PRELIMINARY PLAN FALCON MARKETPLACE

PRELIMINARY PLAN FOR
FALCON MARKETPLACE
FALCON, COLORADO

ISSUE	DATE
EXHIBIT	1-17-17
REVISION	8-13-18
DESIGNED BY:	TDM
DRAWN BY:	KGV
CHECKED BY:	TDM
FILE NAME:

PRELIMINARY
SITE PLAN

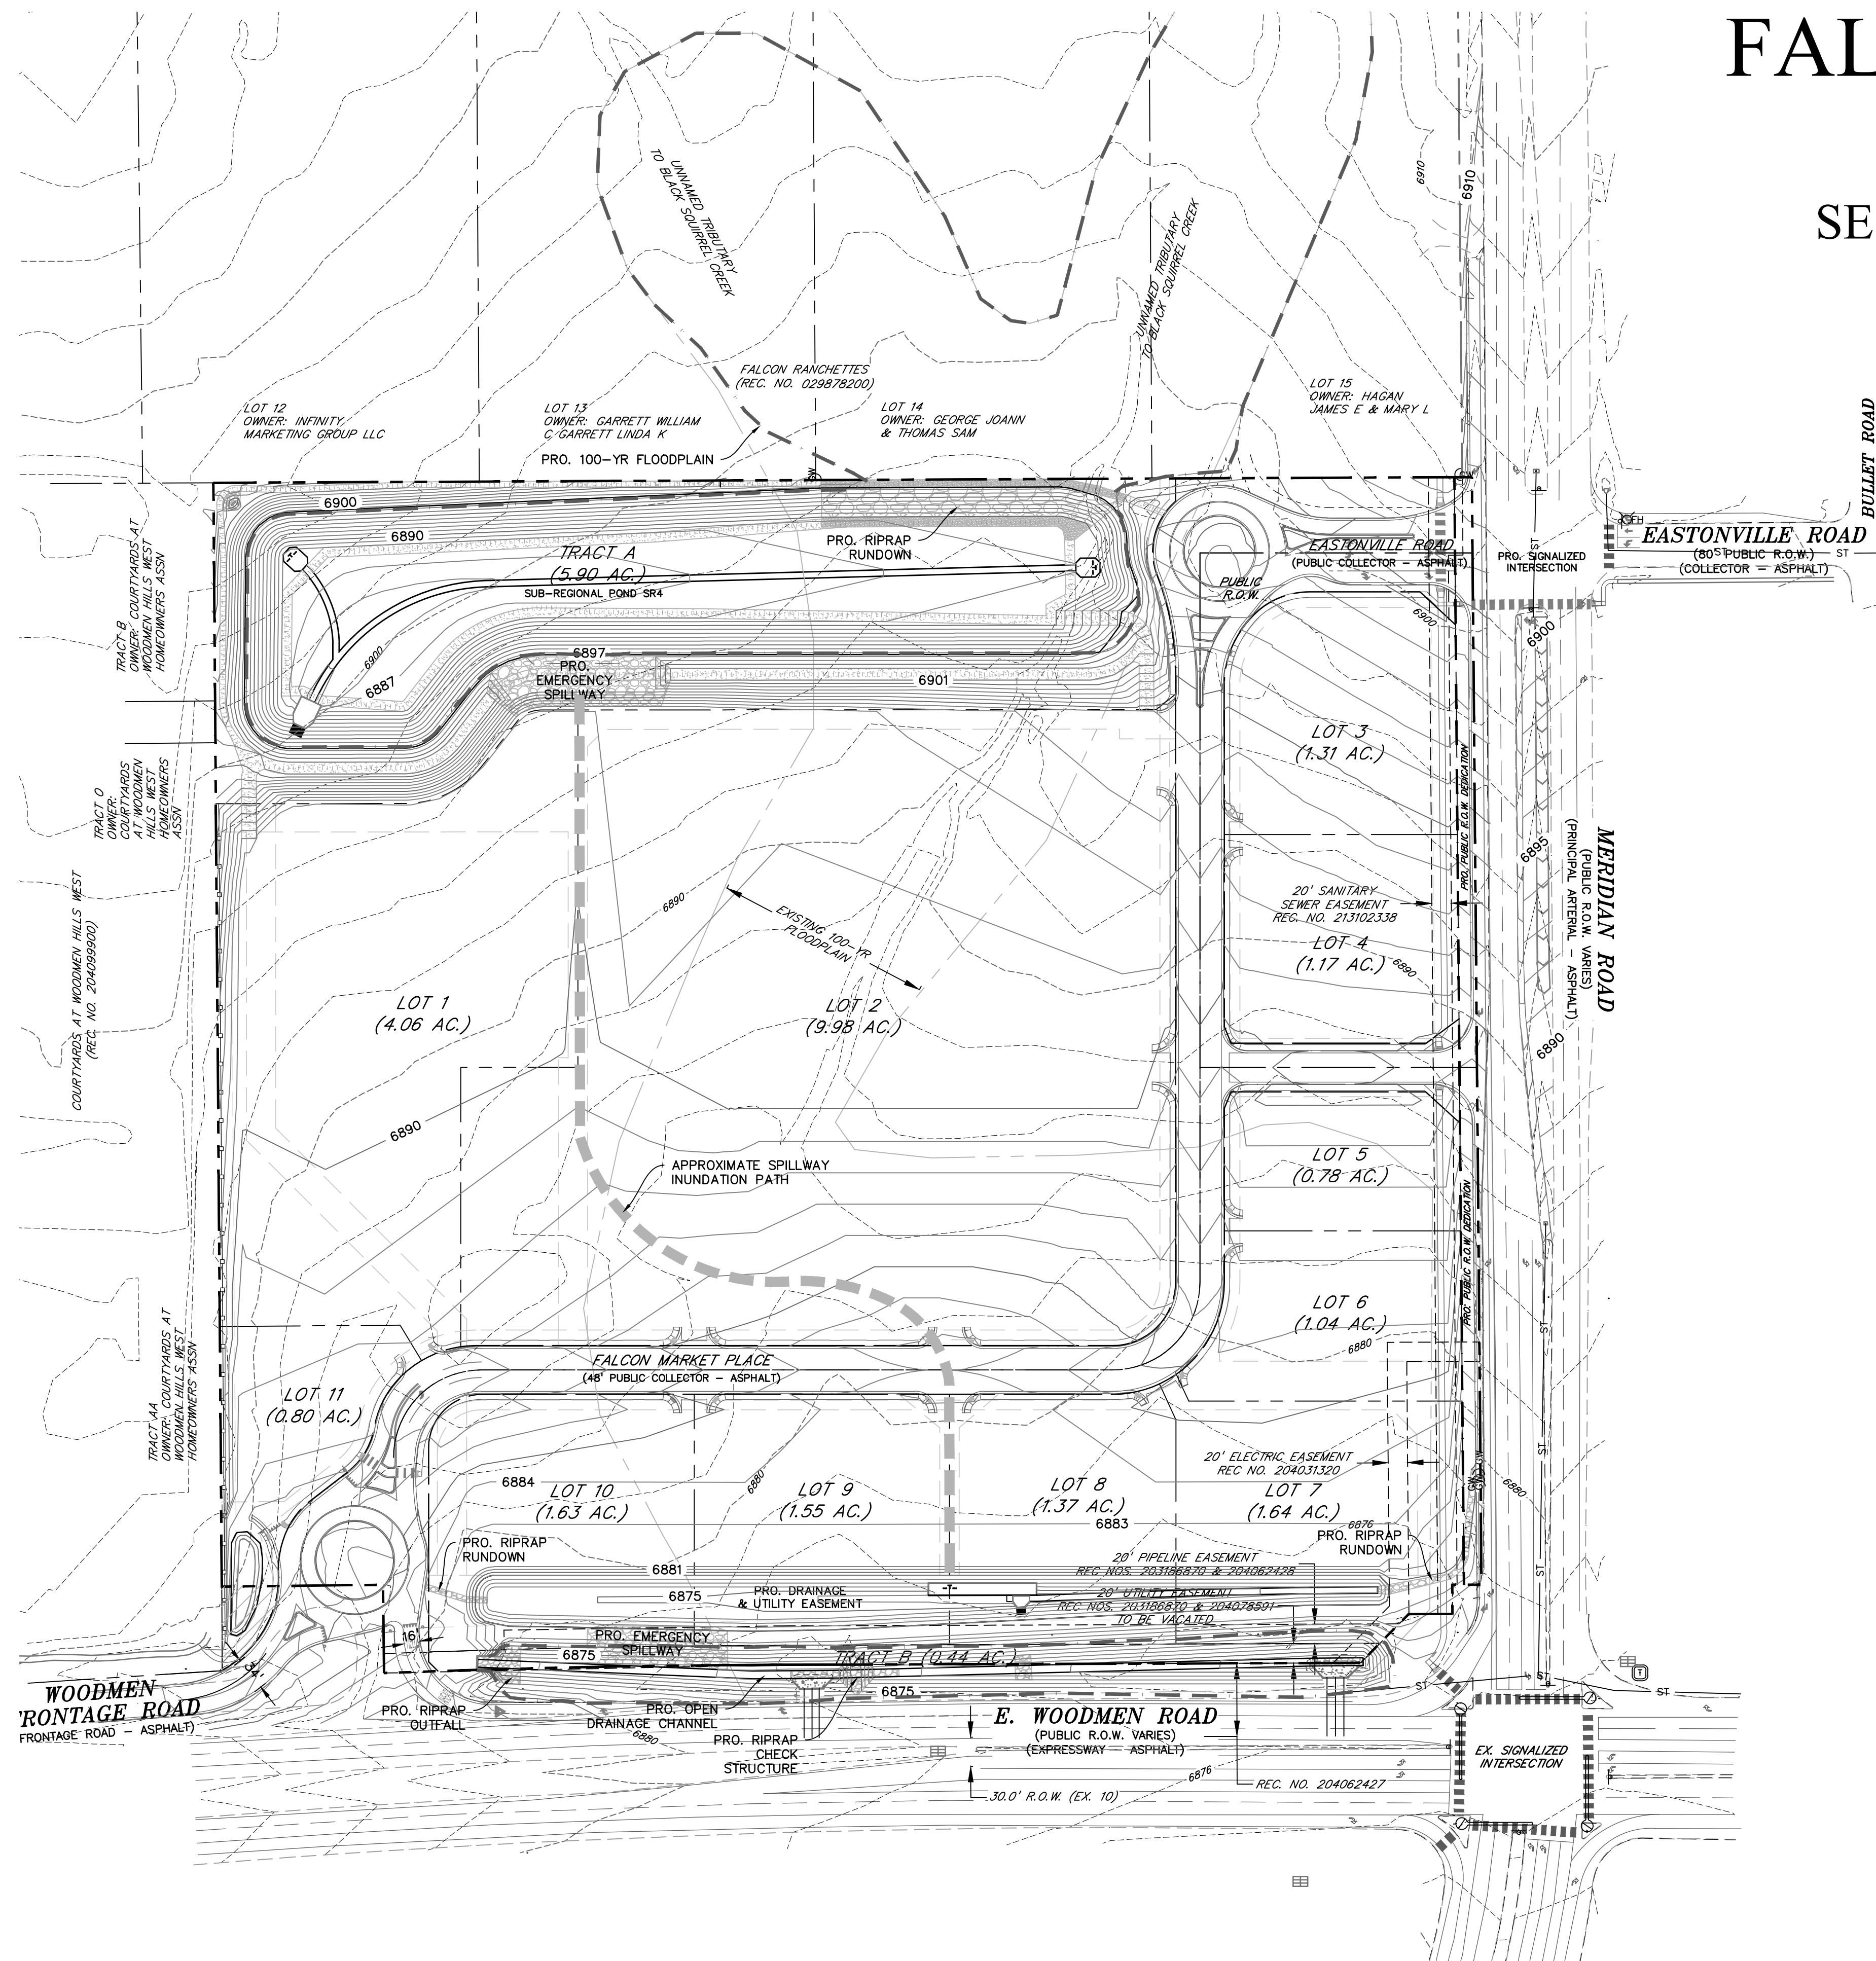
Show and label pond maintenance roads.

Show PI easements on this road matching the cross-section.

SHEET: 3 OF 4

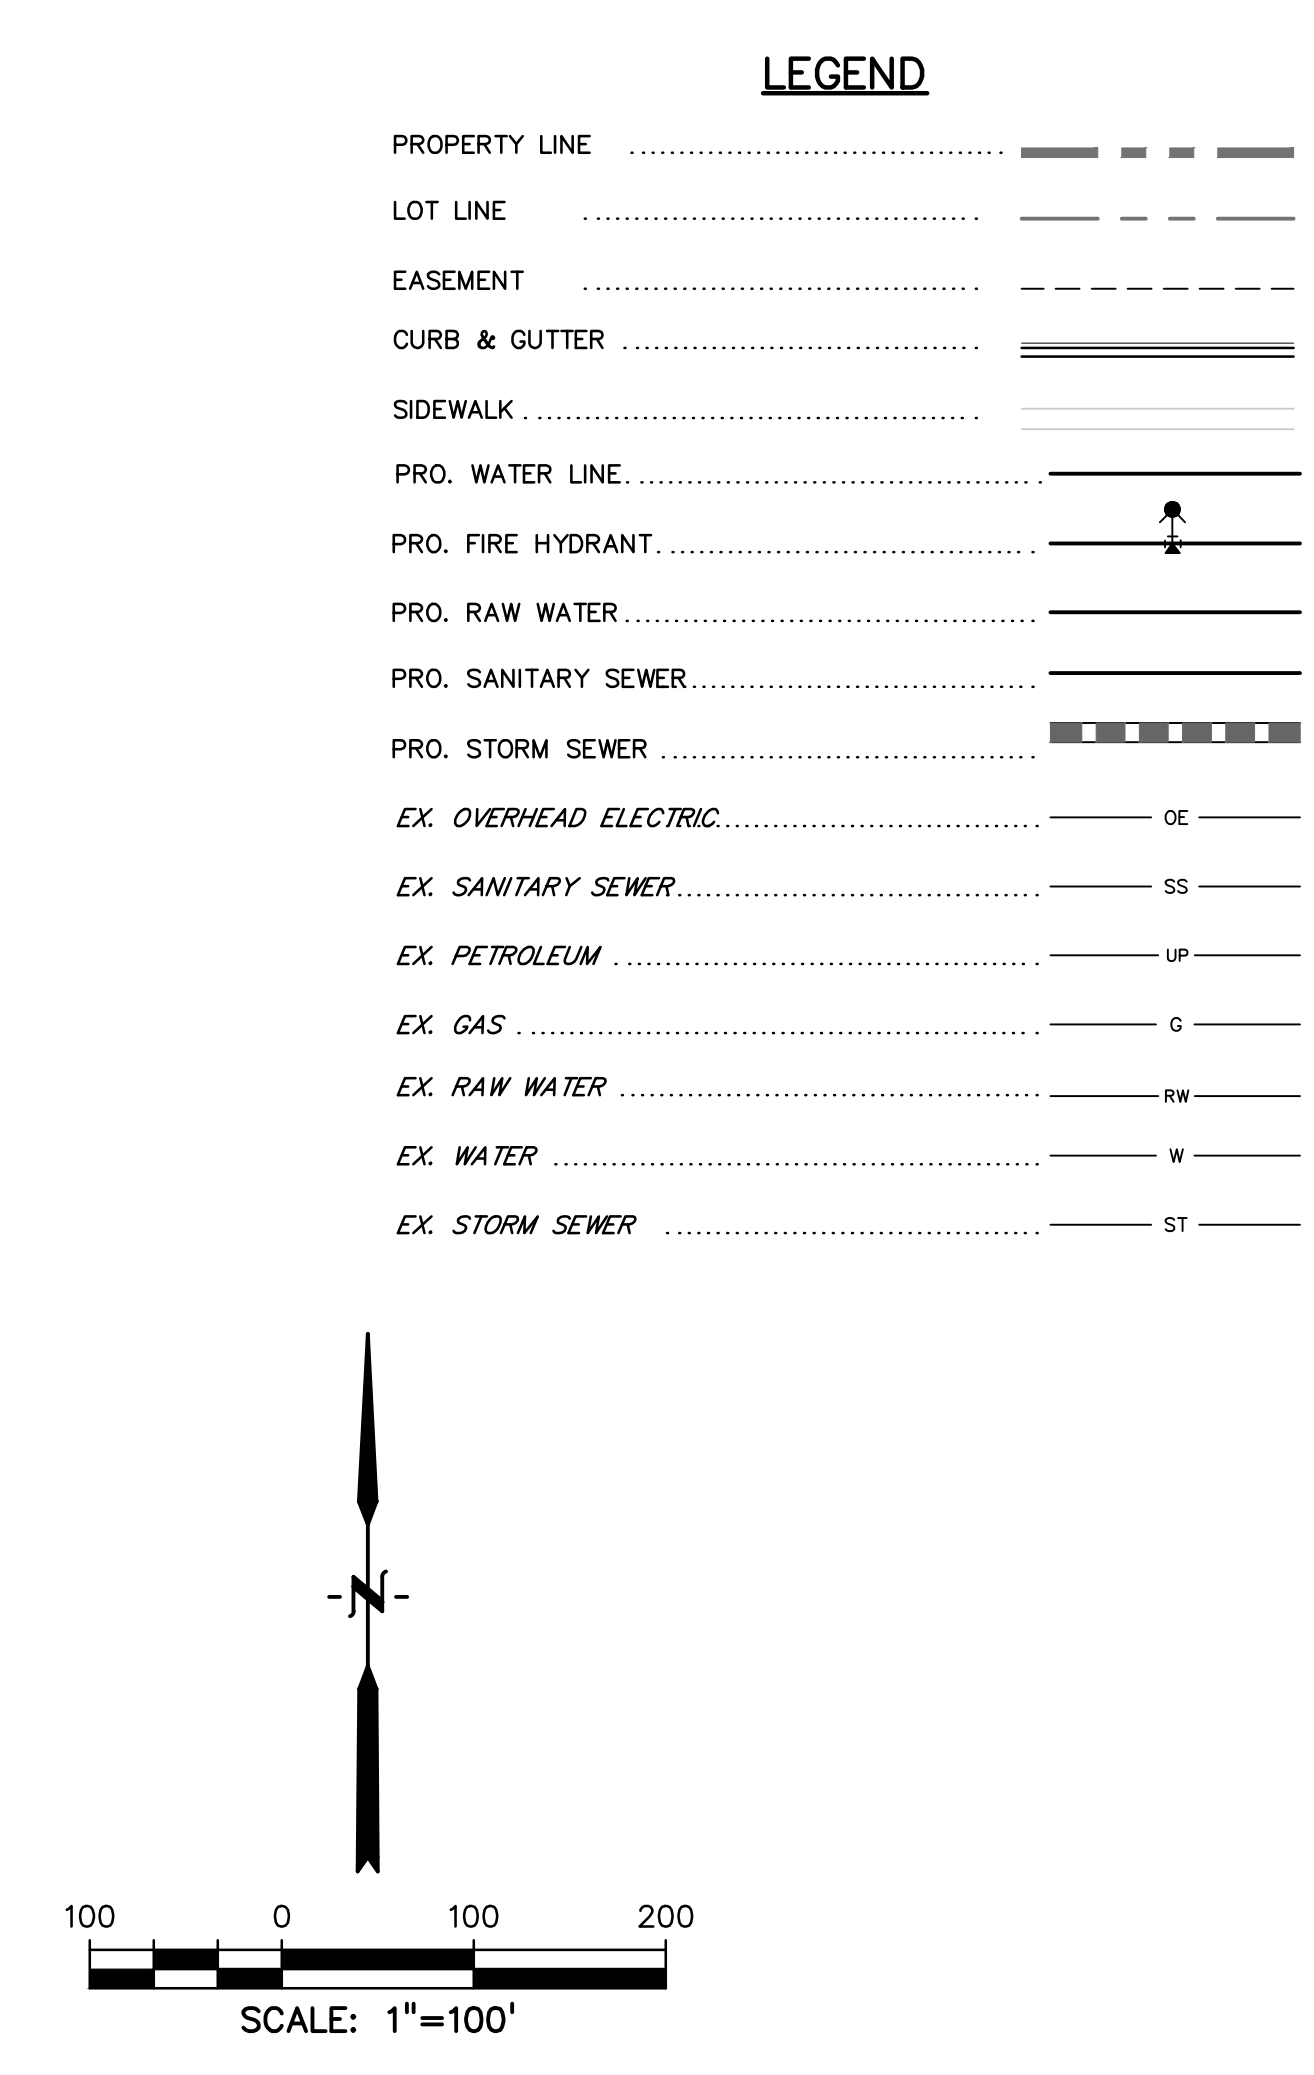
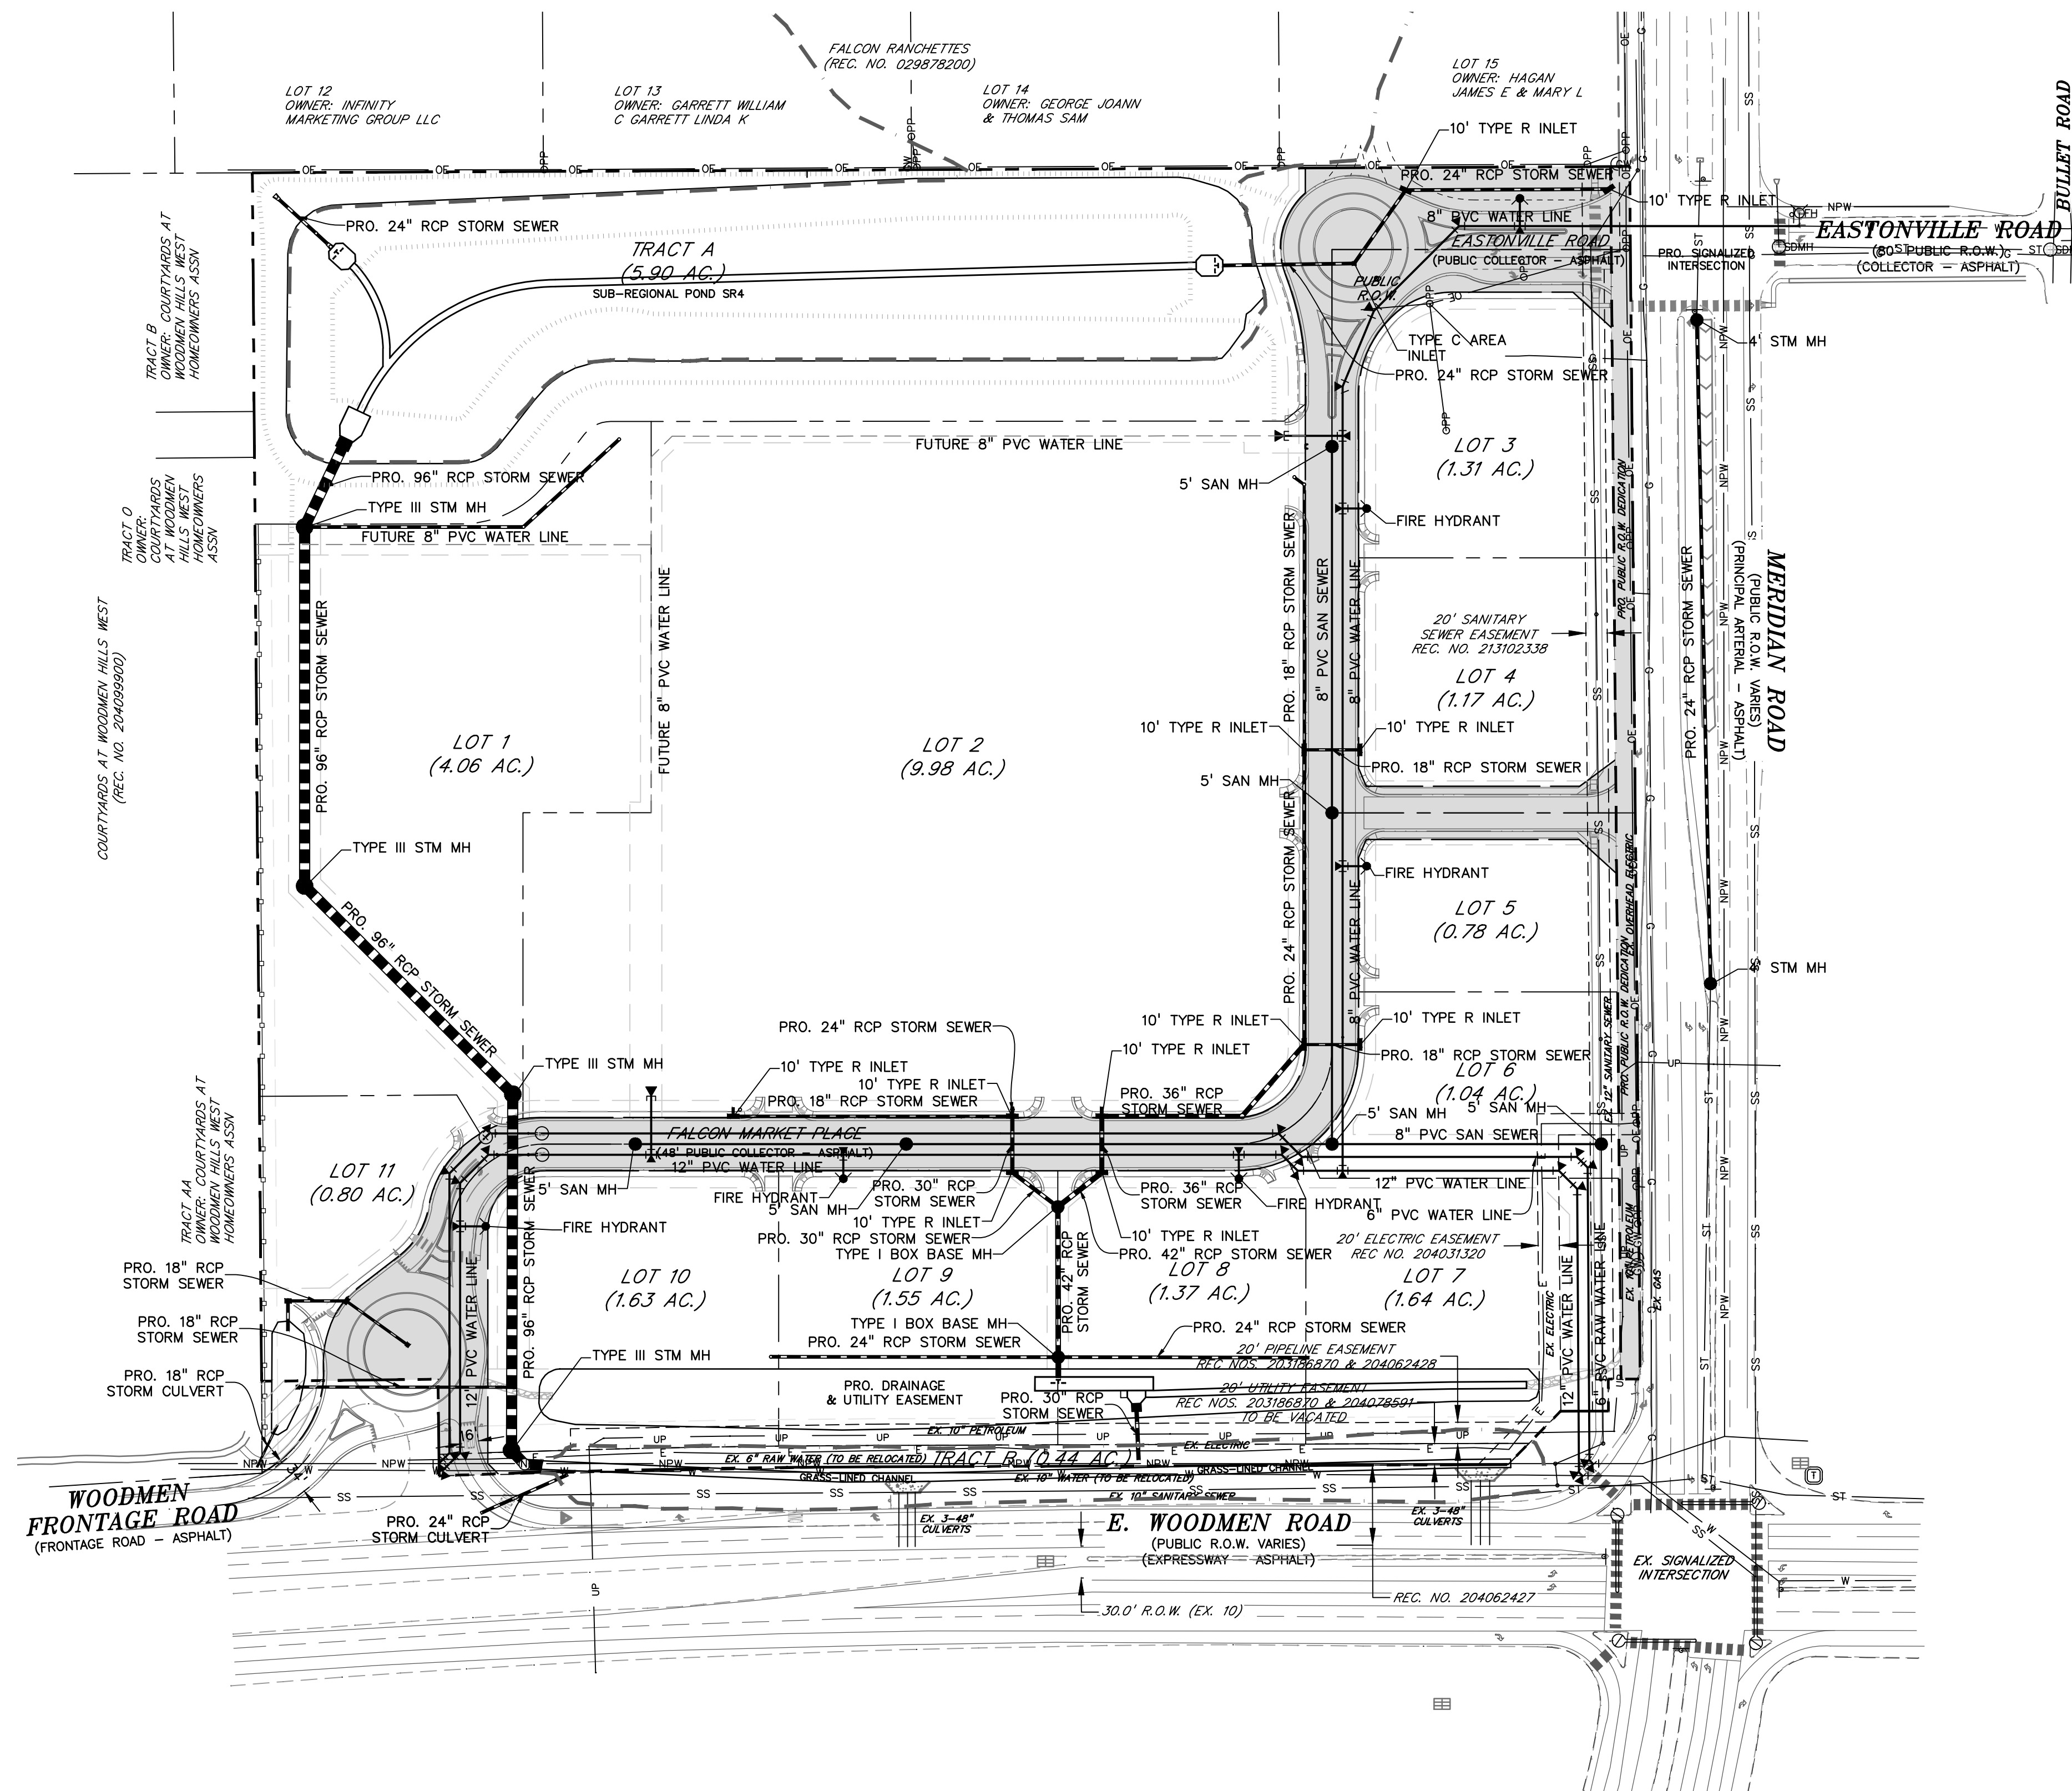
Show and label approximate spillway inundation path.
